Our Case Number: ABP-314724-22

Re: Railway (Metrolink - Estuary to Charlemont via Dublin Airport) Order [2022]
Metrolink. Estuary through Swords, Dublin Airport, Ballymun, Glasnevin and City Centre to Charlemont, Co. Dublin

Re: Submission to Application

ABP Reg. Ref: NA29N.314724
Applicant: National Transport Authority (TII)
For: Estuary through Swords, Dublin Airport, Ballymun, Glasnevin
and City Centre to Charlemont, Co. Dublin (Metrolink)

Project	Drawing Title	Drawing Status
Estuary - Seatown Landscape Layout Preliminary Design Issue		S4
Drawing N°	ML1-JAI-ARL-SC01_XX-DR-Y-00001	
Scales Original Size A1	1:1000	Sheet 1 of 3

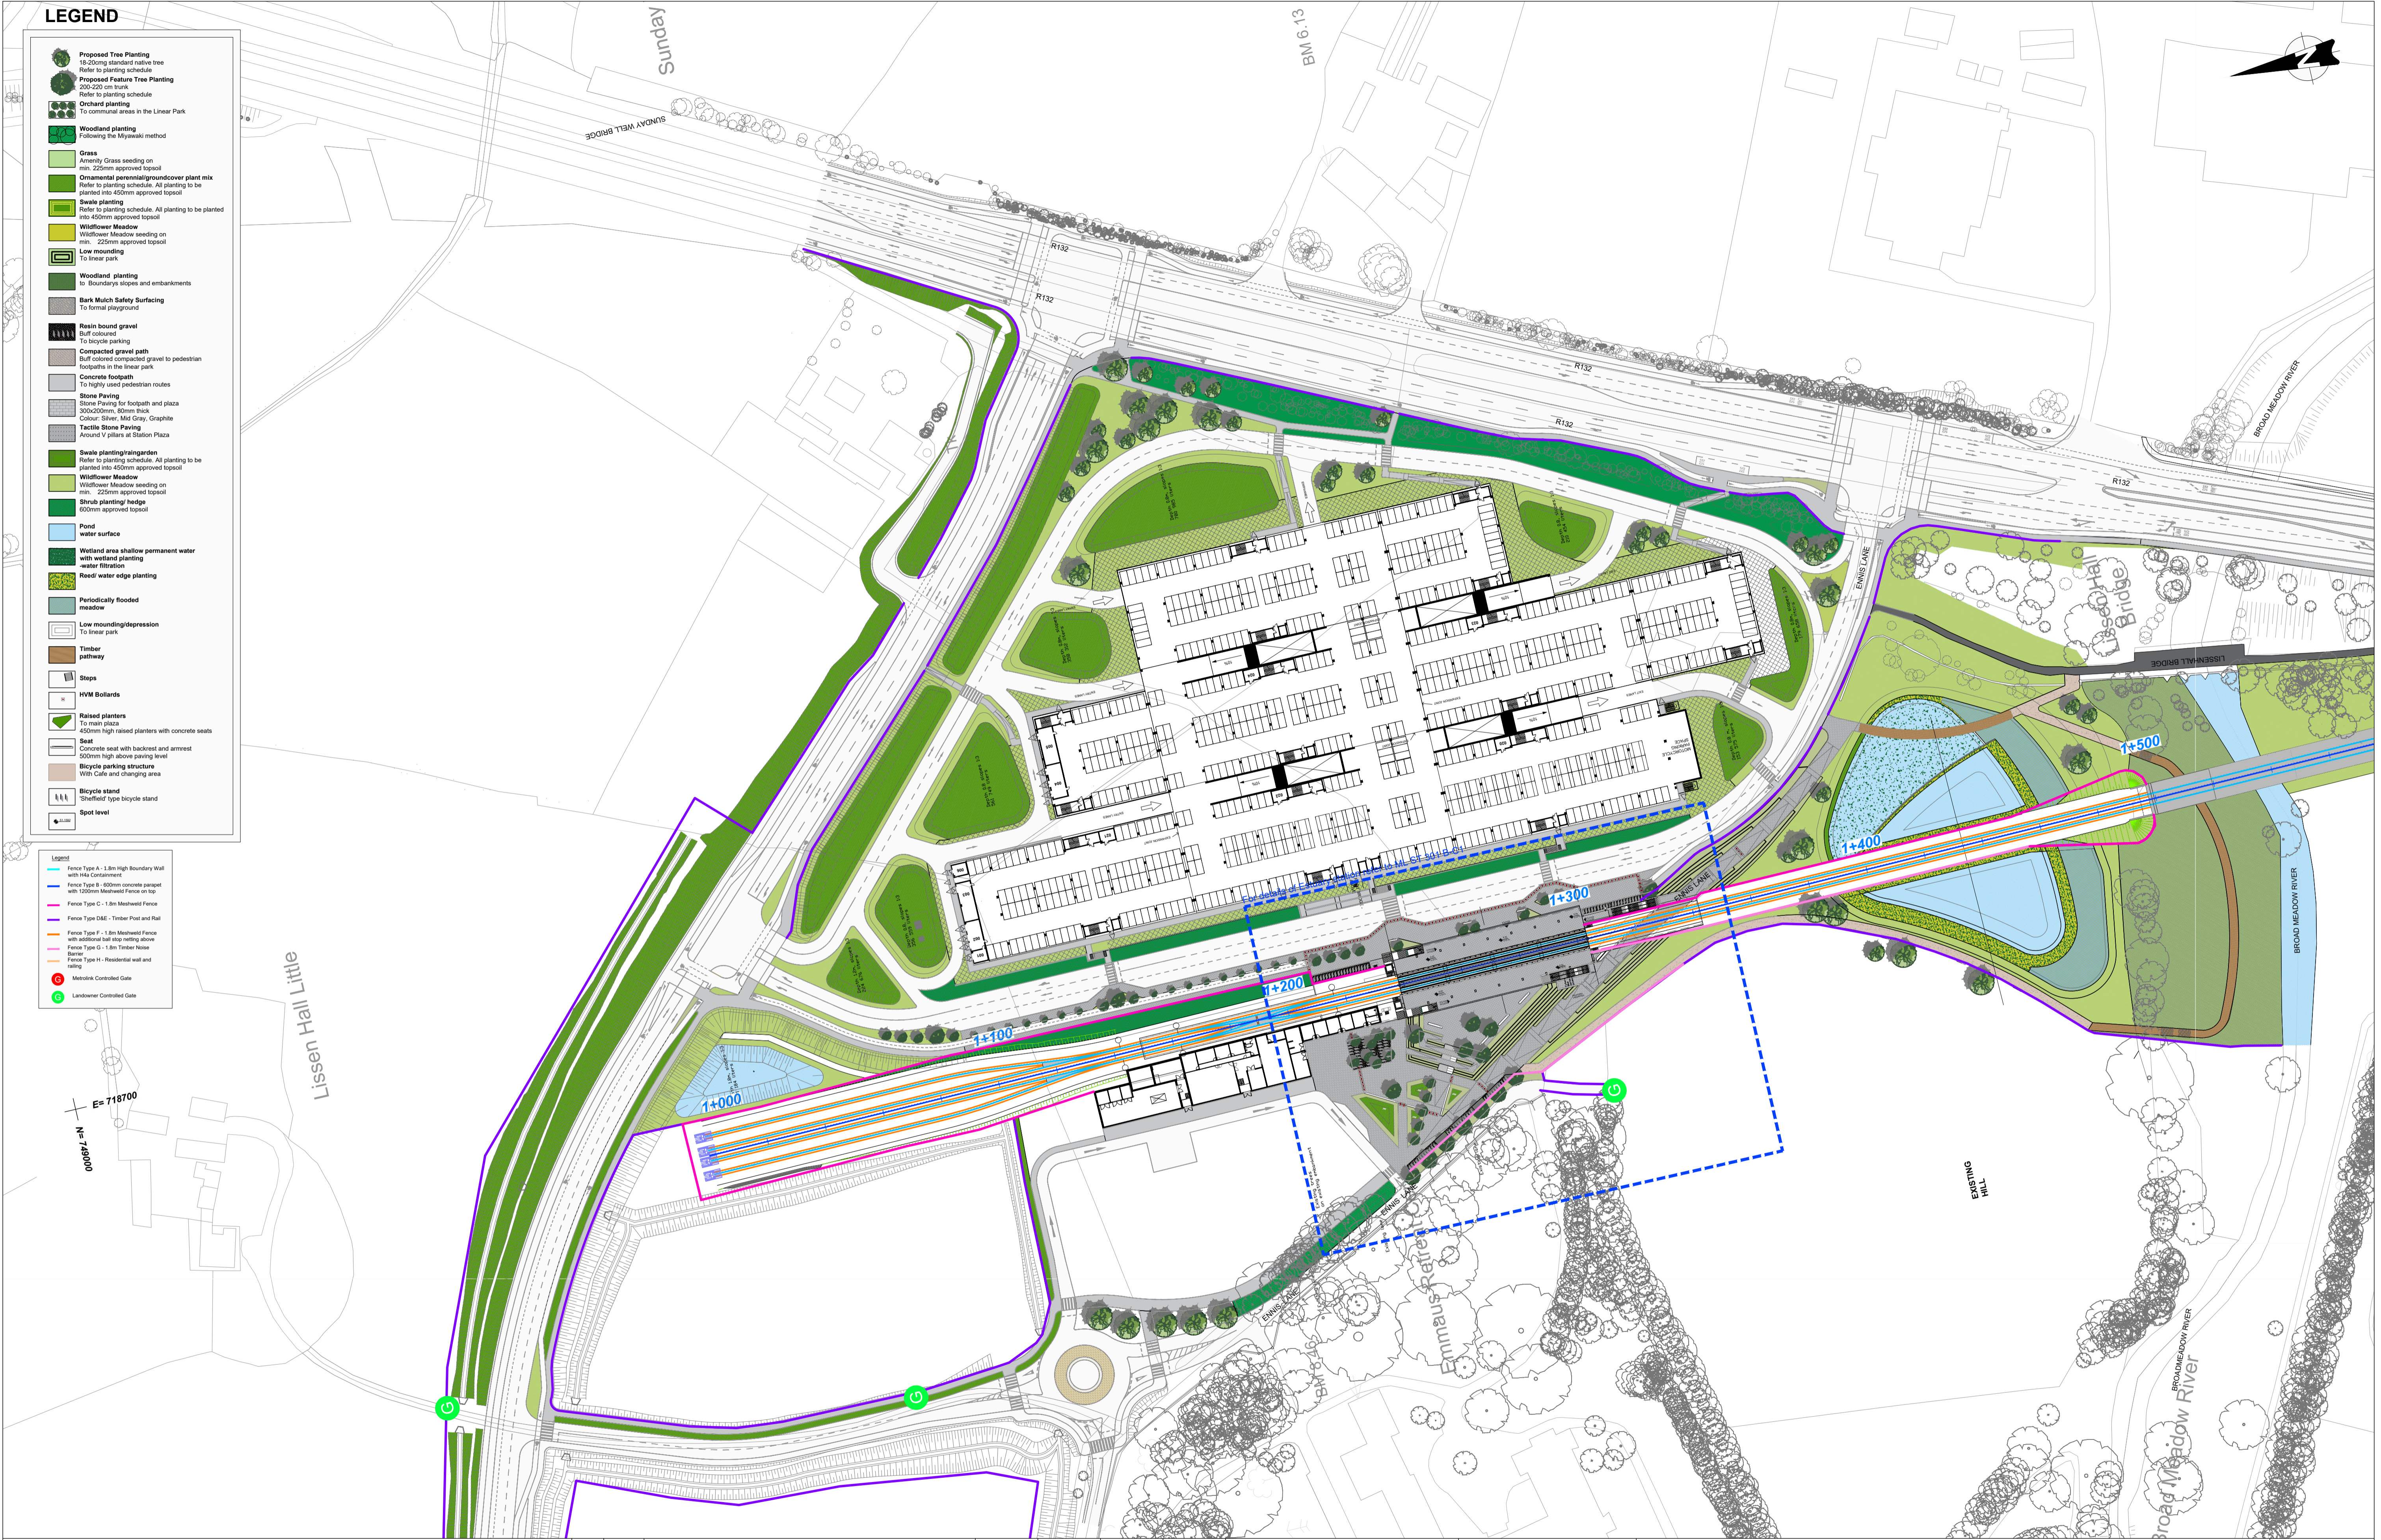
- 1.4 The Open Space proposed on Drawing No. ML1-JAI-ARL-SC01_XX-DR-Y-00003 (Drawing title *Estuary-Sea town Landscape Layout*) does not conform to best practice and is contrary to the FCCDP..

- 1.5 We attach drawing no. ML1-JAI-ARL-SC01_XX-DR-Y-00003 referred to above, and have included mark ups which illustrate:
- a. The specific Open Space area of concern (area shaded in red, and black dotted line)

- b. The location and orientation of adjoining properties, which highlight that this Open Space will not be overlooked, and will instead be exposed to gable walls and rear gardens

- 1.6 We are concerned that the current design which has not taken into consideration Best Practice and with the absence of passive surveillance will result in anti-social behaviour.

- 1.7 The applicants acknowledge that residents closest to Open Space would view the intervisibility as a reduction of their privacy. Notwithstanding this acknowledgement, no apparent meaningful measures are proposed for residents directly adjoining the proposed open space.

- 1.8 It is unclear from the information provided in the planning application and associated drawings, what boundary treatments, if any, are being proposed for the southwest boundary of the Open Space which adjoins our property and rear garden. There is no apparent proposal for screening or fencing. The boundary of our rear garden which directly adjoins the proposed Open Space consists of a dwelling built up against our boundary wall that is under compulsory purchase order for the metro north (is therefore due to be demolished) and hedging. A lack of appropriate screening will result in an unacceptable intrusion of our privacy.

1. Provide for revised plans and particulars in relation to the Open Space referred to above, ensuring that a safe-by-design approach is taken to avoid anti-social behaviour and to ensure residential amenity is not negatively affected.
2. Provide revised noise and vibration surveying and assessment to ensure that all potential significant effects of the Metro Scheme are addressed during the planning process and appropriate mitigation are detailed in the EIAR for any such significant impact, such as interference with sleep, as referred to by the applicant.
